East Park Energy Development Consent Order (EN010141)

Comments on the Applicant's Virtual Site Inspection Plan

Comments regarding the Applicant's proposed UAV drone and 360-degree video walkover surveys

Dwg no
Figure 1

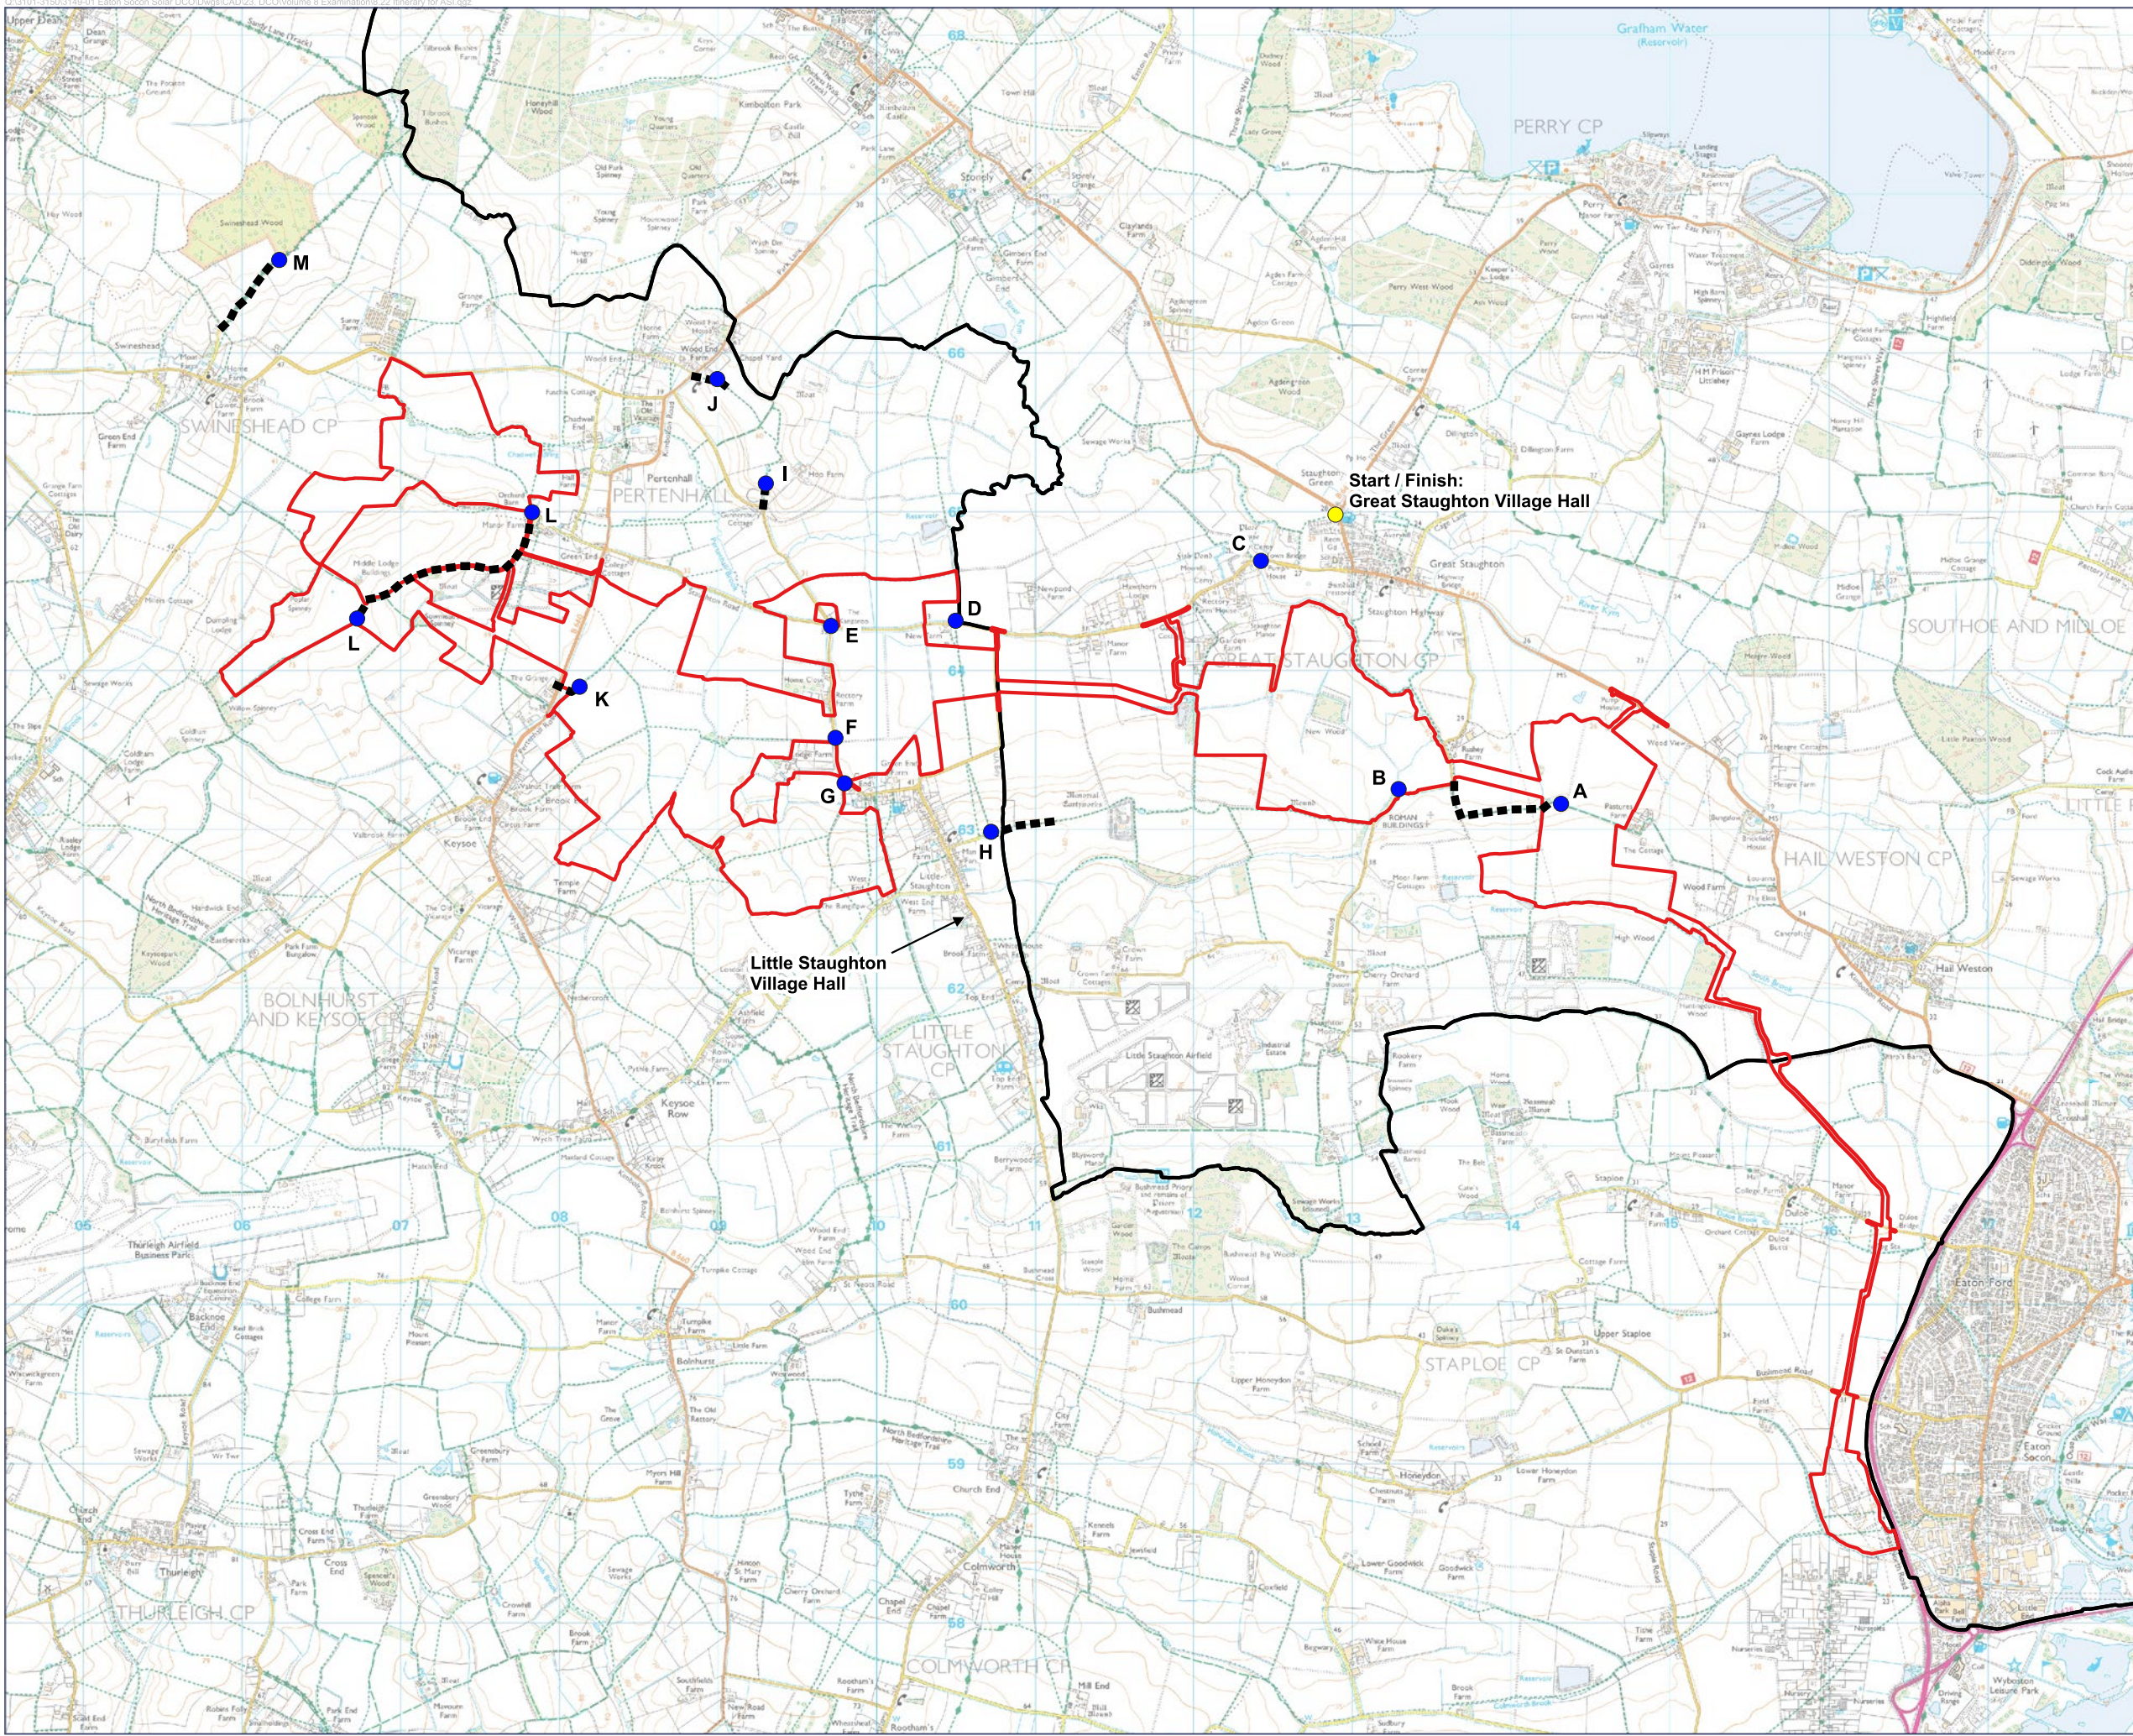
Route A1–A2

SEPE submits that digital surveys would not adequately demonstrate the likely impact of the proposed development on walkers and equestrians using the bridleway in close proximity to the proposed BESS compound.

This route should also be experienced from ground level using the footpath towards High Wood in order properly to appreciate how the proposed East Park infrastructure would interact cumulatively with the existing solar installation and the additional consented solar development in the surrounding area.

Route B1–B2

This route demonstrates the elevated nature of the surrounding landscape and the extensive views across the proposed development area.

SEPE submits that camera-based surveys materially reduce the apparent significance of elevation and landscape prominence. The visual relationship between the viewer and the wider landscape can only properly be appreciated on the ground.

Point E

SEPE considers this location particularly important because it demonstrates the visibility of the proposed site from the crossroads and along the route towards Pertenhall.

The site is relatively open and visually exposed from this location. The area also incorporates shared access arrangements associated with existing agricultural activity.

A physical inspection is required fully to appreciate the relationship between the proposed infrastructure, surrounding receptors and the openness of the existing landscape.

Point F

This route is currently well used by walkers and experiences relatively limited agricultural vehicle traffic.

SEPE is concerned that use of this route by construction vehicles, together with additional fencing and infrastructure, would materially alter its character and create potential safety concerns.

The route is already enclosed in places by existing boundaries. Additional infrastructure would further intensify the sense of enclosure.

SEPE submits that a site visit by the Examining Authority is essential in order properly to assess these effects.

Route G1–G2

This route involves a gradual slope with expansive views across the countryside.

SEPE submits that the significance of these views and the relationship between the proposed infrastructure and the wider landscape can only properly be appreciated through direct on-the-ground experience.

Route H1–H2

This route follows the ridgeline and provides important views towards the Moat and surrounding countryside.

SEPE considers that the proposed development would materially diminish the present landscape value and openness experienced along this route.

Route I1–I2

This route provides reduced but still important views towards the Great Staughton Road corridor.

SEPE submits that the relationship between the viewer, the surrounding topography and the proposed infrastructure is not adequately conveyed through digital media.

Route M1–M2

SEPE considers that views of the proposed development from this location are comparatively limited and therefore does not regard this as an essential location for digital recording.
